DECISION DELEGATED TO HEAD OF PLANNING

Application No: H11-0388-25 **Applicant:** IMN Properties
Proposal: Proposed change of use of existing buildings to form 2 HMO's and 1 bedsit
Location: 39 & 43 West Street Long Sutton Spalding
Terminal Date: 2nd July 2025

Ground Floor Plan
Scale: 1:100

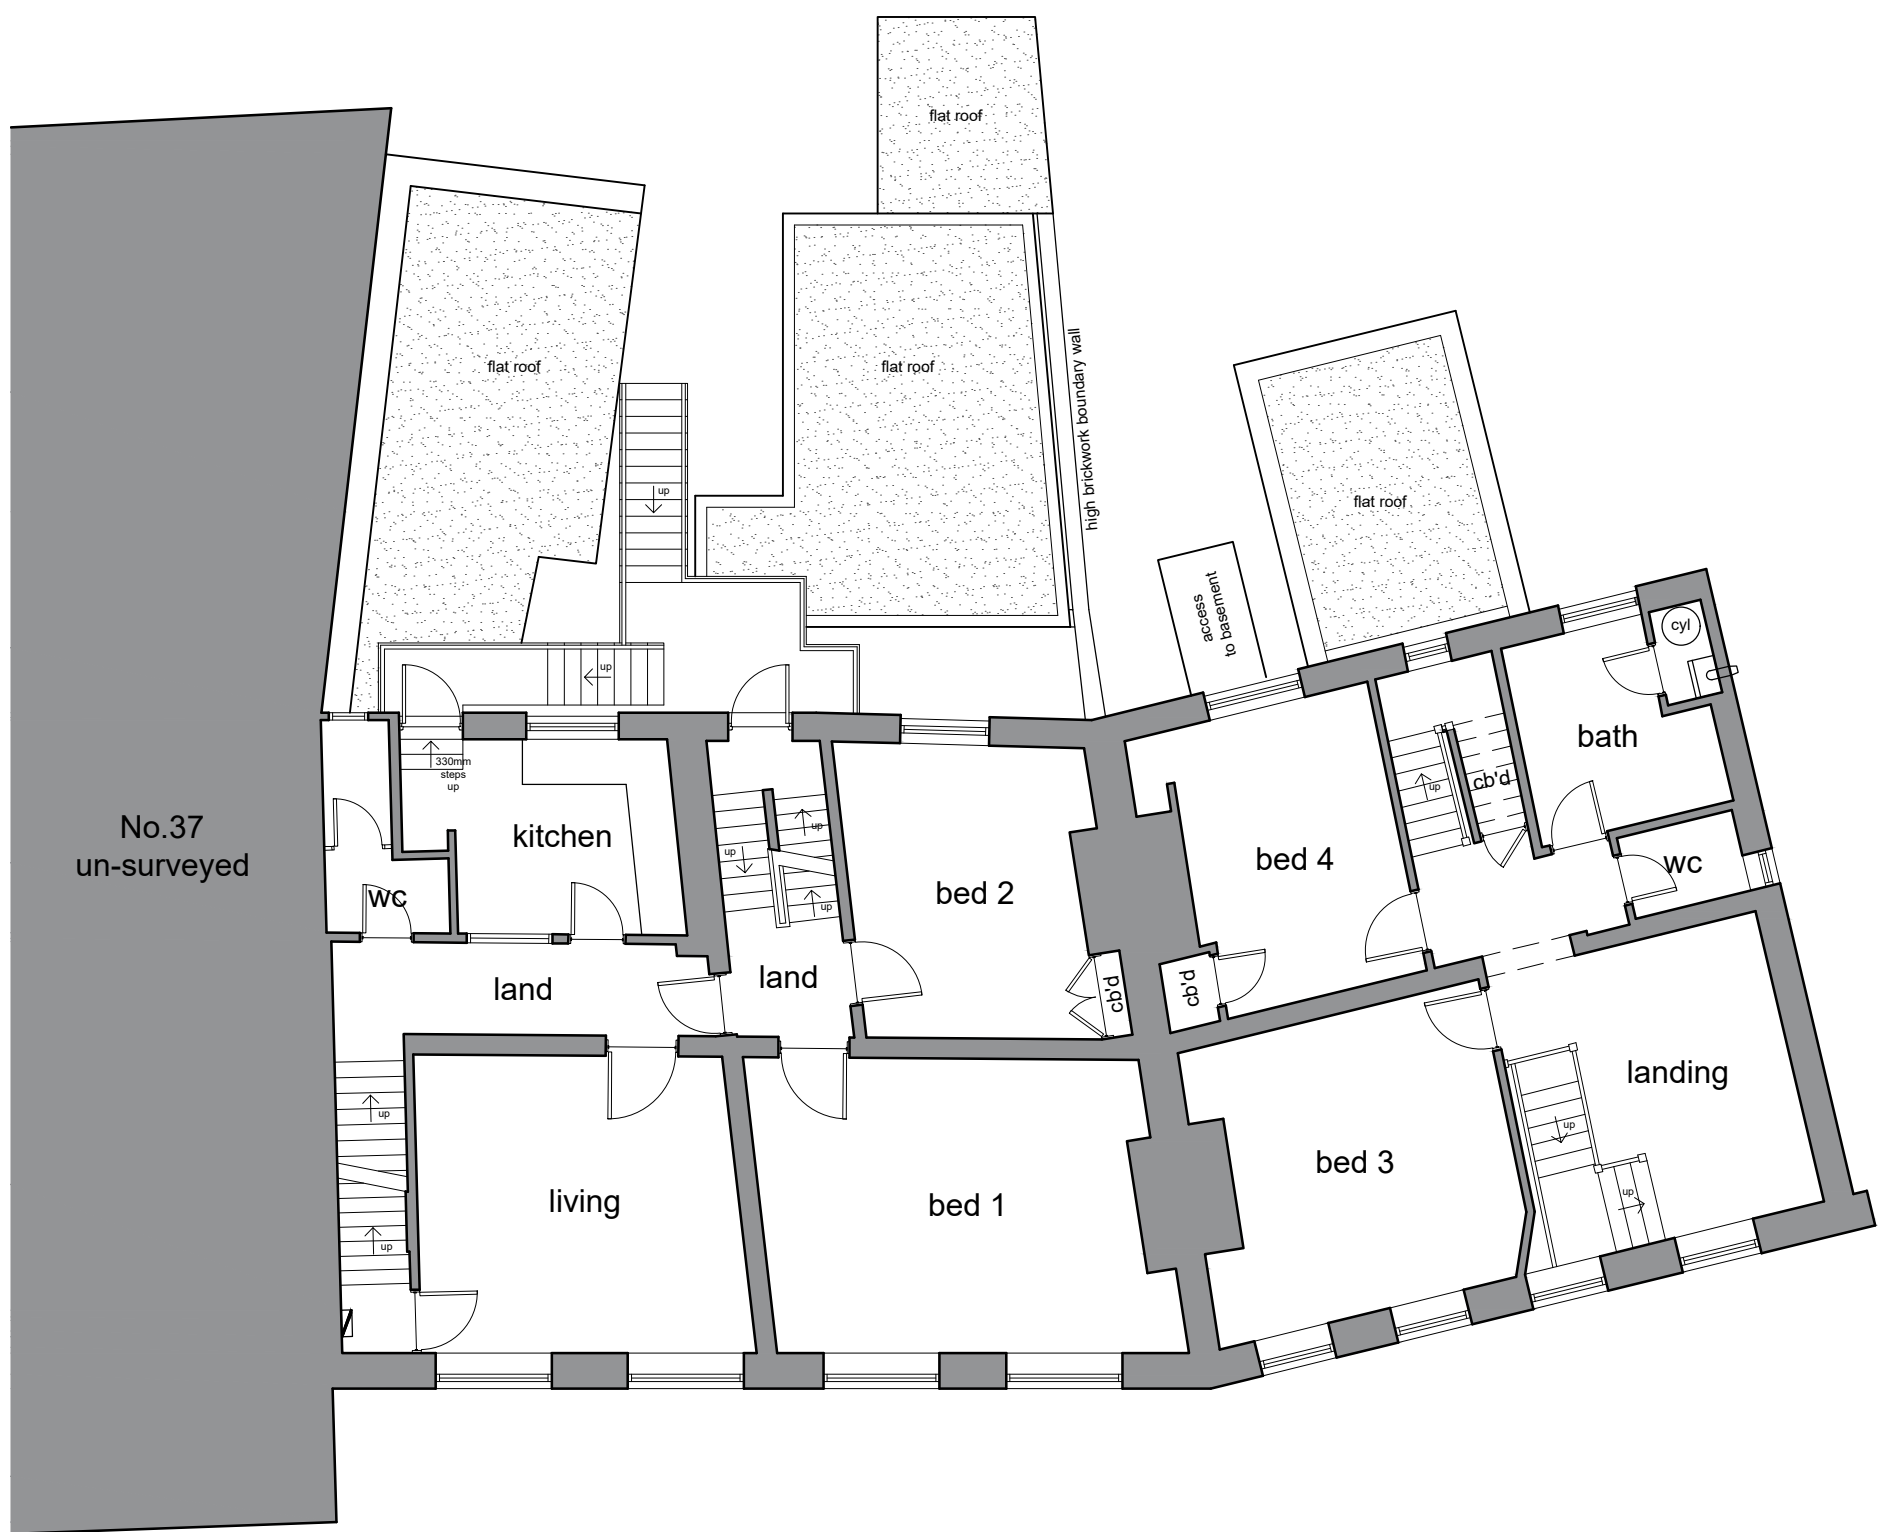
The HIA and submitted drawings lack detail and do not assess the interior of the heritage asset and the effect of the proposed works. It is intended to sub-divide the ground floor of no.39 to create 2 rooms with en-suites, however, the HIA does not provide any explanation of the effect of this on the original plan form of the room. In addition, it is intended to create a door to serve Room 5 but no elevation of this has been provided. This is also the case with the ground floor of no.43 where sub-division and the blocking up of doors are proposed.

The window to Room 2 appears smaller on the floor plan than shown in elevation and the kitchen window serving Rooms 1,2,3 and 4 is not shown in full in elevation.

The window serving Room 4 is not shown in elevation, this directly faces onto the external staircase and given such proximity it is questionable whether it would be possible to open the window. Moreover, concern has been raised at the lack of outlook, given the proximity of Room 4 to the staircase and blank wall of the maisonette, there is also concern at potential levels of unacceptable noise and disturbance to the occupants of this room by users of the external staircase.

There is also no elevation of the door serving Room 5. It is not clear whether this is fully glazed, partially glazed or of solid construction. The provision of one opening to this room, serving both access, ventilation and light is wholly inadequate, and given its proximity to the external staircase and cycle store there is the potential for unacceptable noise and disturbance to arise.

The elevation does not show the full length of the kitchen door. In addition, the en-suite for Room 8 appears some distance from the room itself, however, this is an observation and not an objection.

Rear Elevation
Scale: 1:100

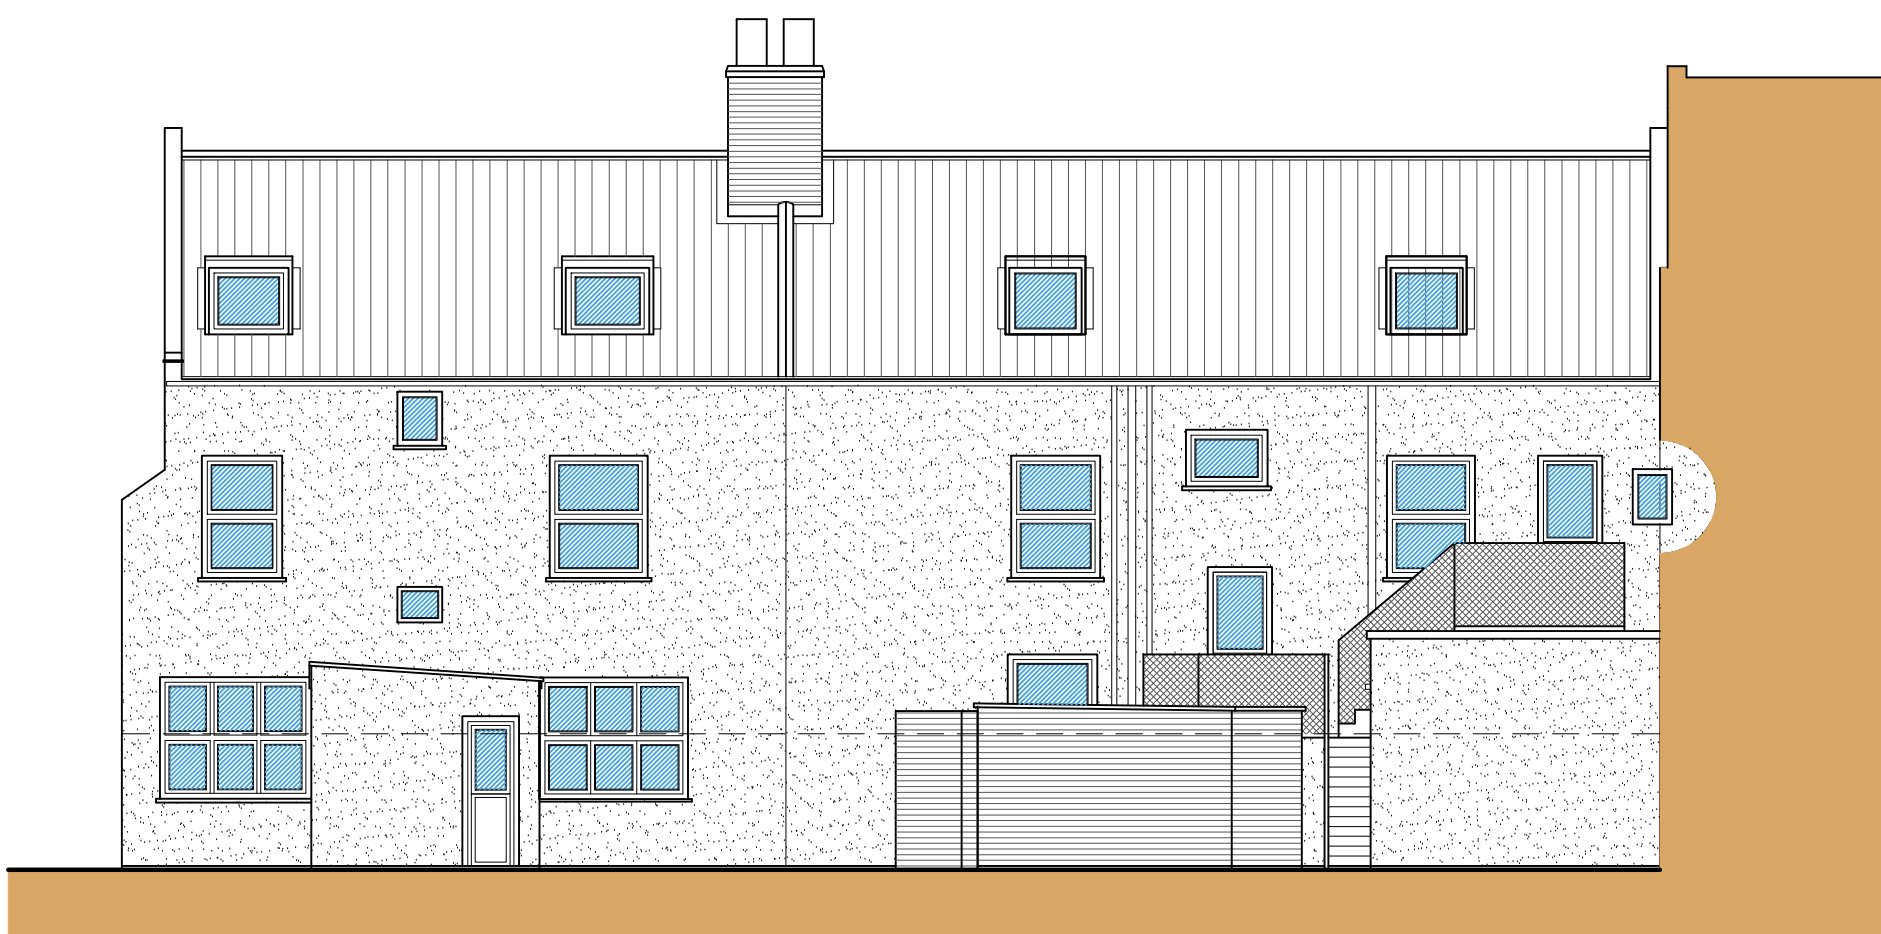
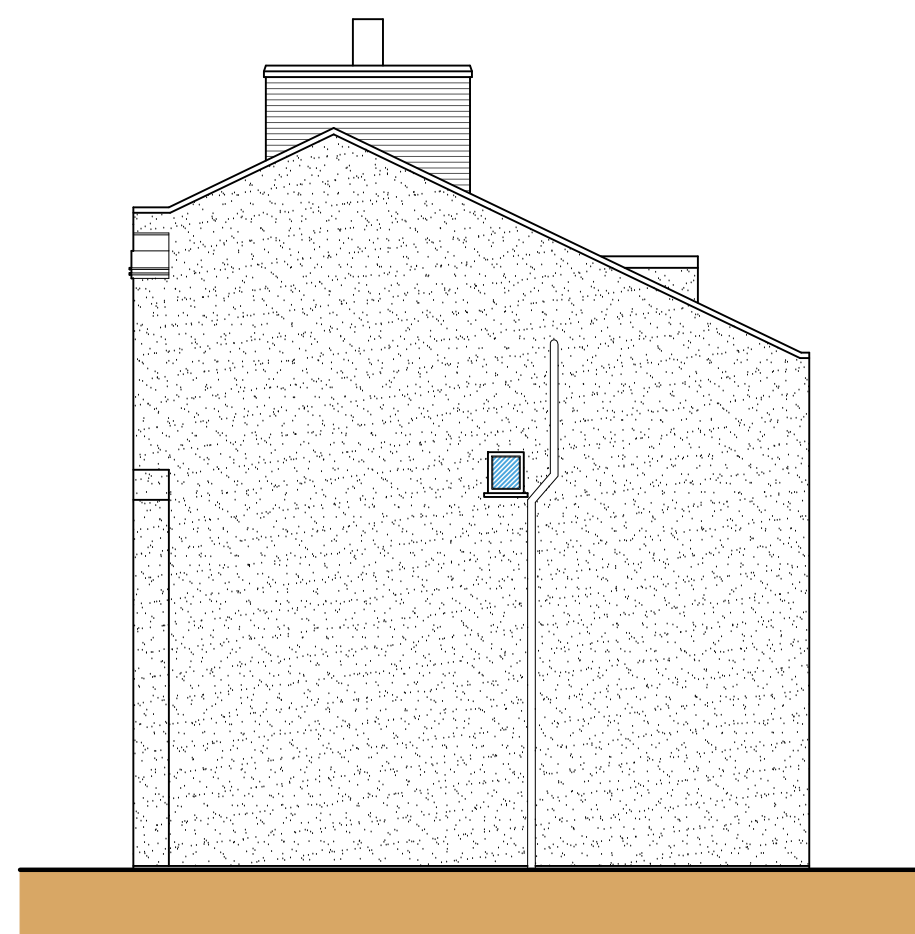
No elevation or cross-section of the basement has been submitted showing the size or design of windows. In addition, there is no elevation of the windows serving Room 3. Concern has been raised at the level of light serving this room and its proximity to a wall which significantly reduces the outlook.
